<b>Title</b>	Noise Documentation Review		
<b>Project</b>	Gatwick Airport DCO		
<b>Reference</b>	28AD.NT.1.1	<b>Author(s)</b>	BHo
<b>Date</b>	13 February 2024	<b>Reviewer</b>	VC

1.1 This note sets out Suono’s initial review of the noise chapter submitted as part of the DCO Environmental Statement (ES), as well as its appendices and specific documents referenced within.

Diagram 7.2.1: WHO 2018 Systematic Review, Probability of Awakenings

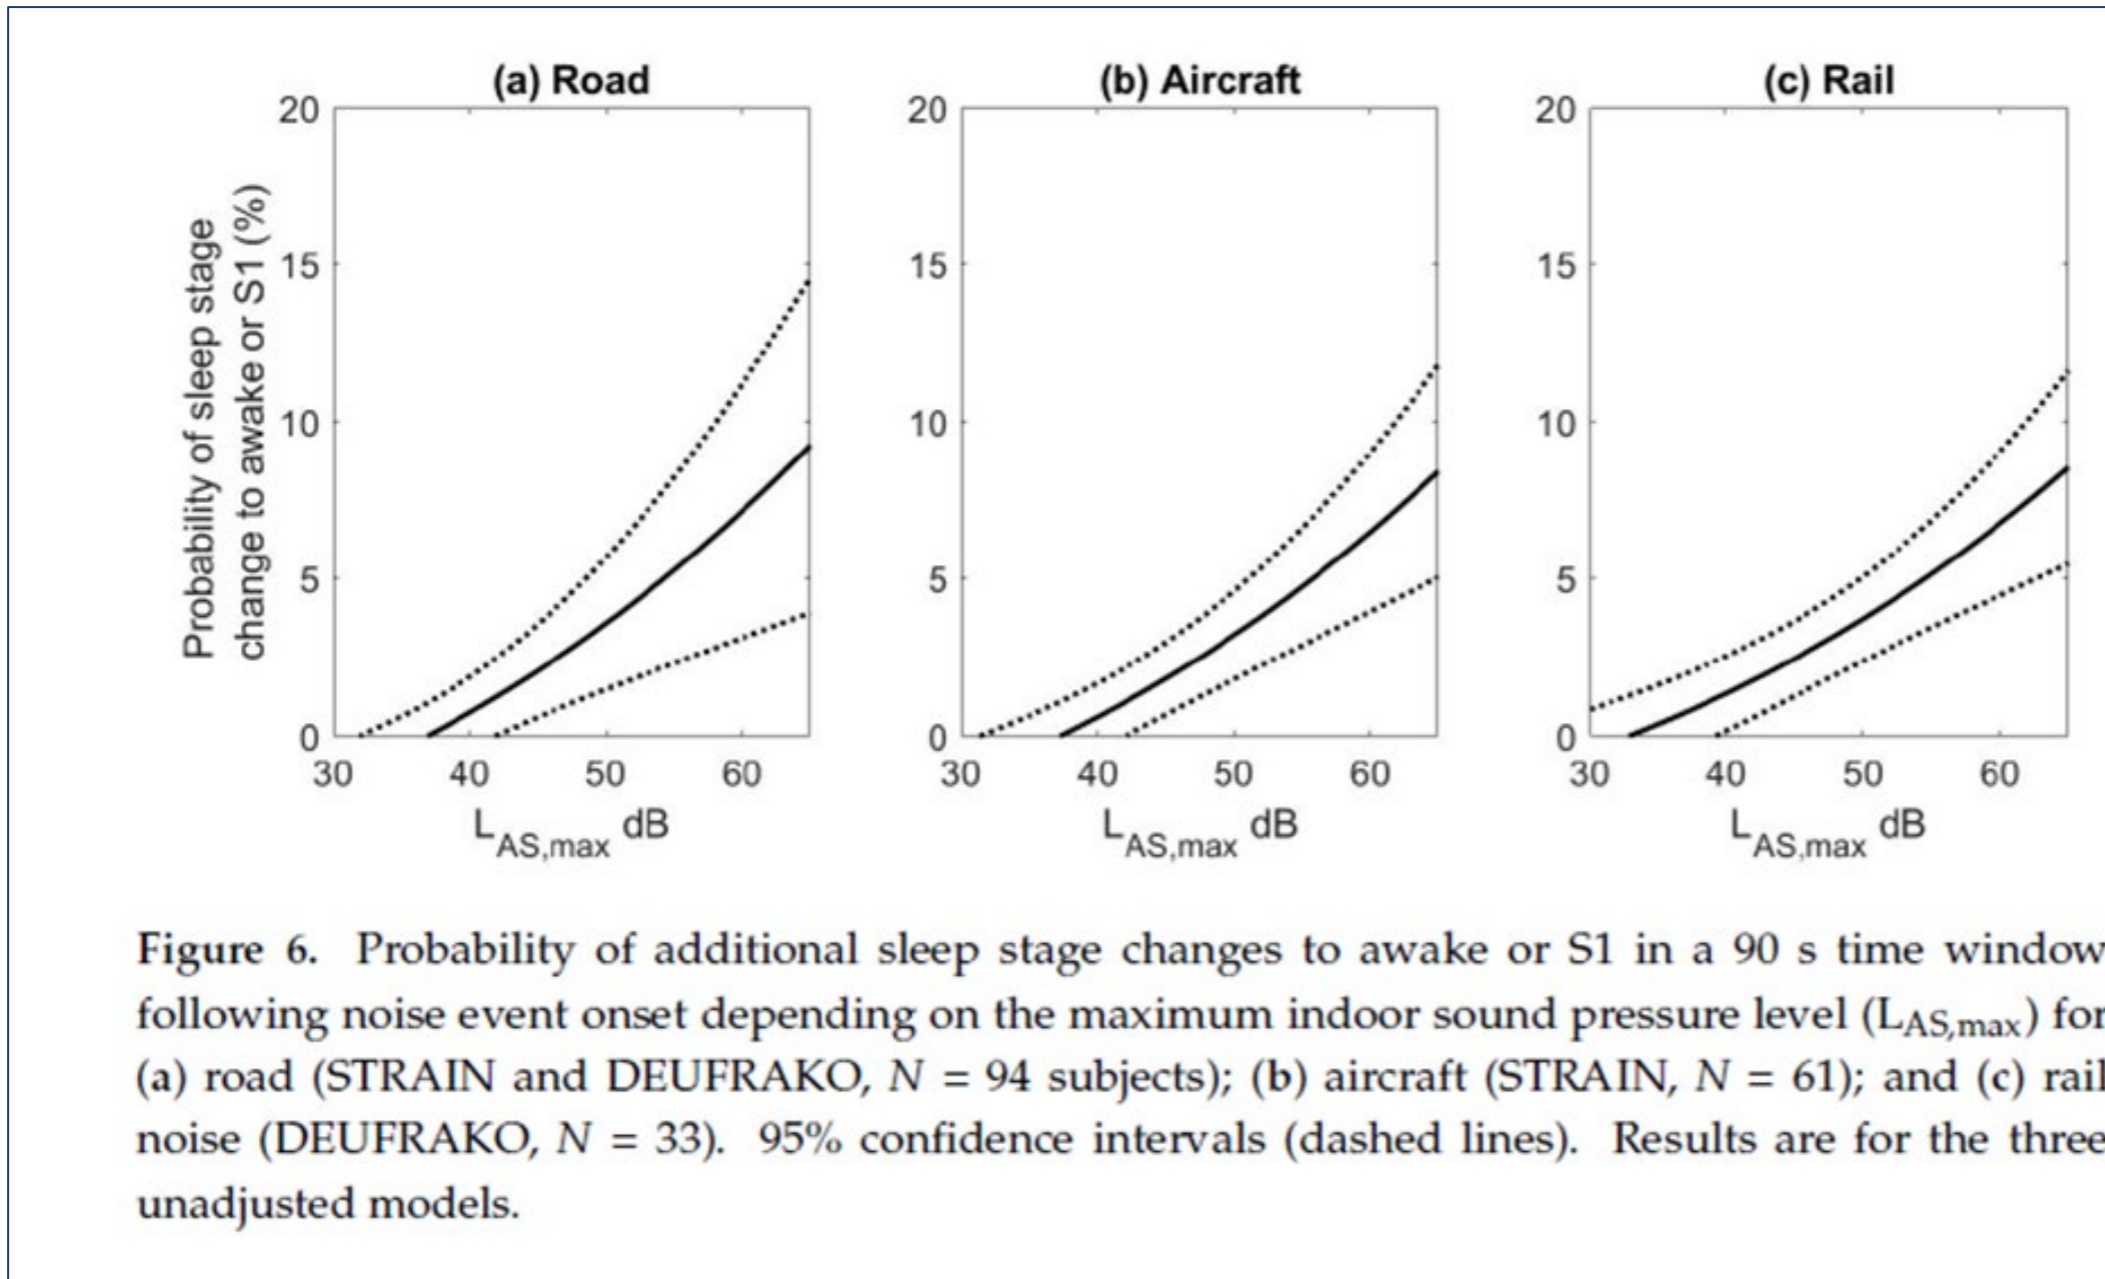
3.7 Appendix 14.9.2 Air Noise Modelling [APP-172] states at the end of section 7.4.7, “*it is currently unclear how many additional noise-induced awakenings are acceptable and without consequences for sleep recuperation and health*” and does not at any point propose a threshold or criteria.

3.8 The Heathrow Airport 3<sup>rd</sup> Runway Preliminary Environmental Impact Report (PEIR) [Heathrow Expansion PEIR, Chapter 17: Noise and Vibration, 2019] set a SOAEL of one additional awakening due to aircraft noise (year average), which applies to a combination of air and ground noise. The recent Bristol Airport expansion also set this as a determinant of SOAEL.

3.9 GAL underestimate the likelihood of awakening through only assessing airborne aircraft, when noise levels from individual ground-borne events have also been calculated and presented in the ES. These must be included. The Applicant should update their awakening assessment to include both air and ground noise sources and compare this against a SOAEL of one additional awakening over the year.
